## NSW RURAL FIRE SERVICE

Your reference: SSD-10394  
Our reference: DA20191113001033-EIS & DA  
Exhibition-1

**State Significant Development - Health Services Facility  
St John of God Hospital 235 Grose Vale Road North Richmond NSW, 11//DP1134453**

Figure 5 Vegetation and Slope

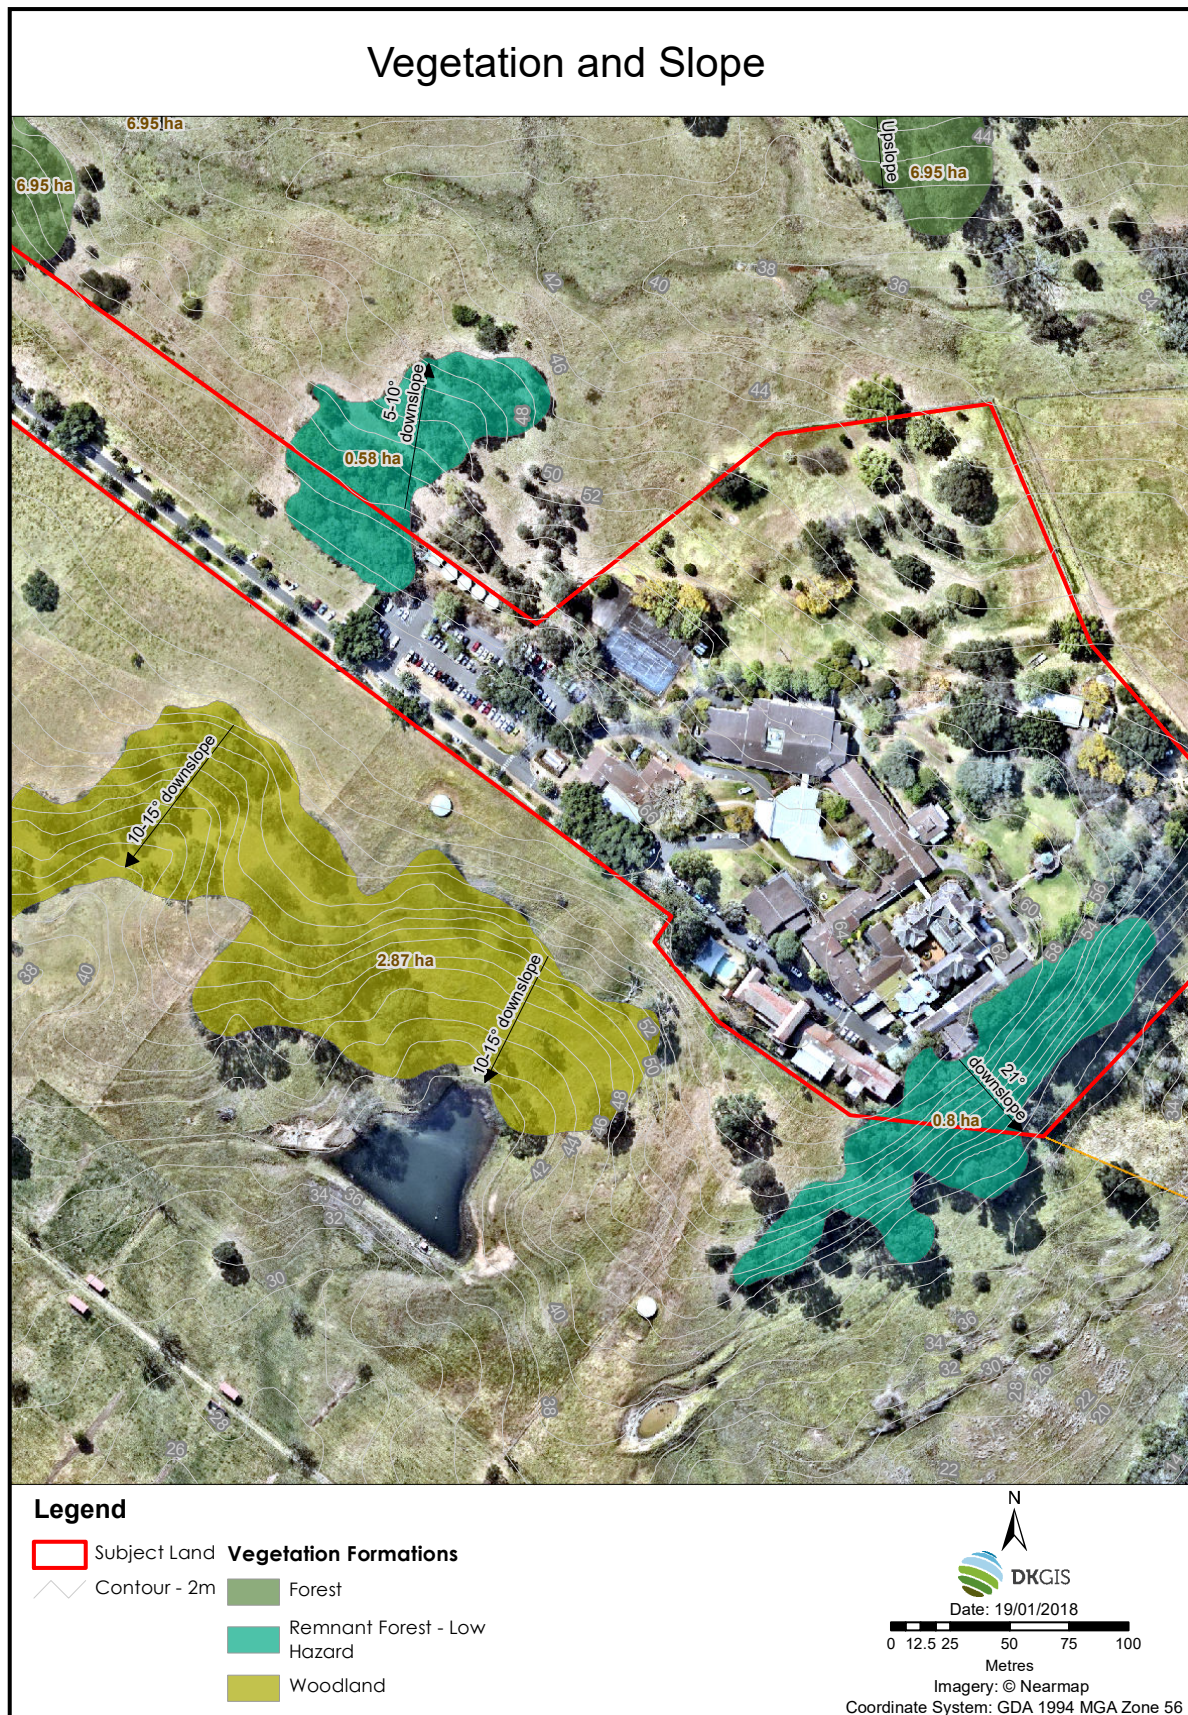
- Provide information on management of existing vegetation along the southeastern site boundary for consideration as an APZ due to the low bush fire risk posed by the vegetation.

In this regard, the bush fire assessment report has considered the vegetation on the southeastern aspect as remnant forest. Considering the limited extent of vegetation, management of under storey and limited width, it will not pose a bush fire risk equivalent to forest. Due to a downslope of greater than 20 degrees within this vegetation, management as an Inner Protection Area (IPA) may be difficult. A vegetation management plan (VMP) can be prepared for the entire retained vegetation within the subject site in order to achieve the requirements of inner protection area (IPA) in accordance with the requirements of Appendix 4 of *Planning for Bush Fire Protection 2019*.

Figure 6 Detailed Slope Map (updated showing relocated Wellness Centre)

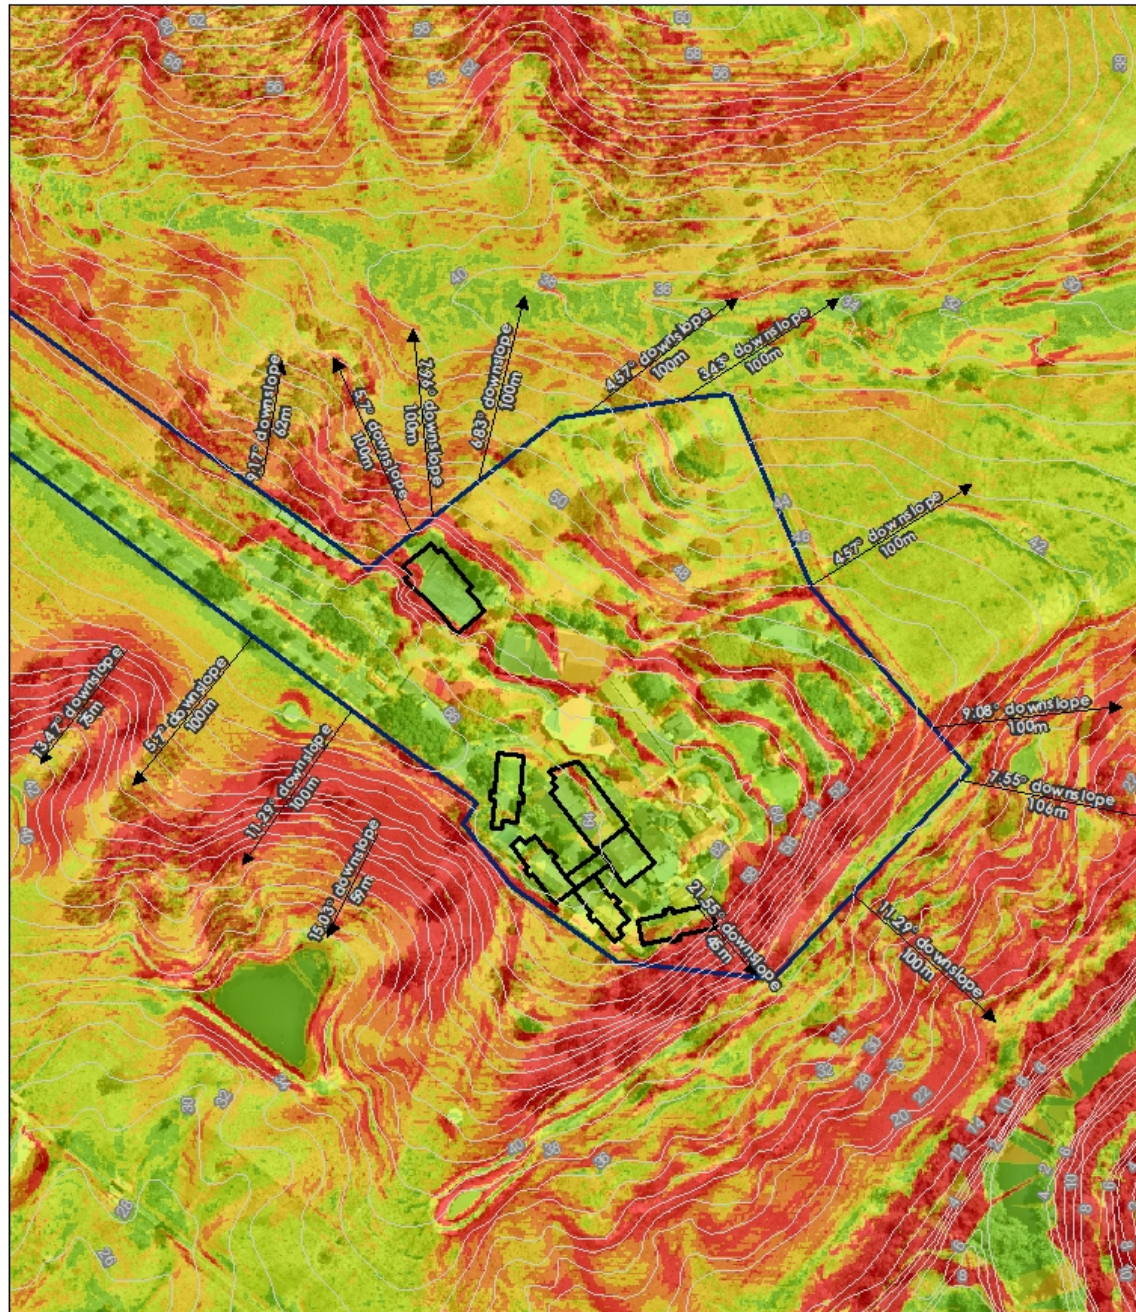
- Provide additional information to demonstrate that the proposed new buildings i.e. the Wellness Centre; Residence Pavilions and Garden Pavilions can achieve asset protection zone (APZ) requirement as per Table A1.12.1 of *Planning for Bush Fire Protection 2019*.

In this regard, the bush fire assessment report has proposed easement on the adjoining eastern Lot 12 DP1134453 and adjoining western Lot 14 DP 703300 for APZ management, however, no formal documentation is provided for consideration of such an arrangement. The proposed Wellness Centre will require a minimum APZ of 45 metres on the northern aspect; and the proposed Residence Pavilions and Garden Pavilions will require an APZ of 50 metres on the western and southeastern aspect in order to achieve a radiant heat exposure of 10 kW/m<sup>2</sup>.
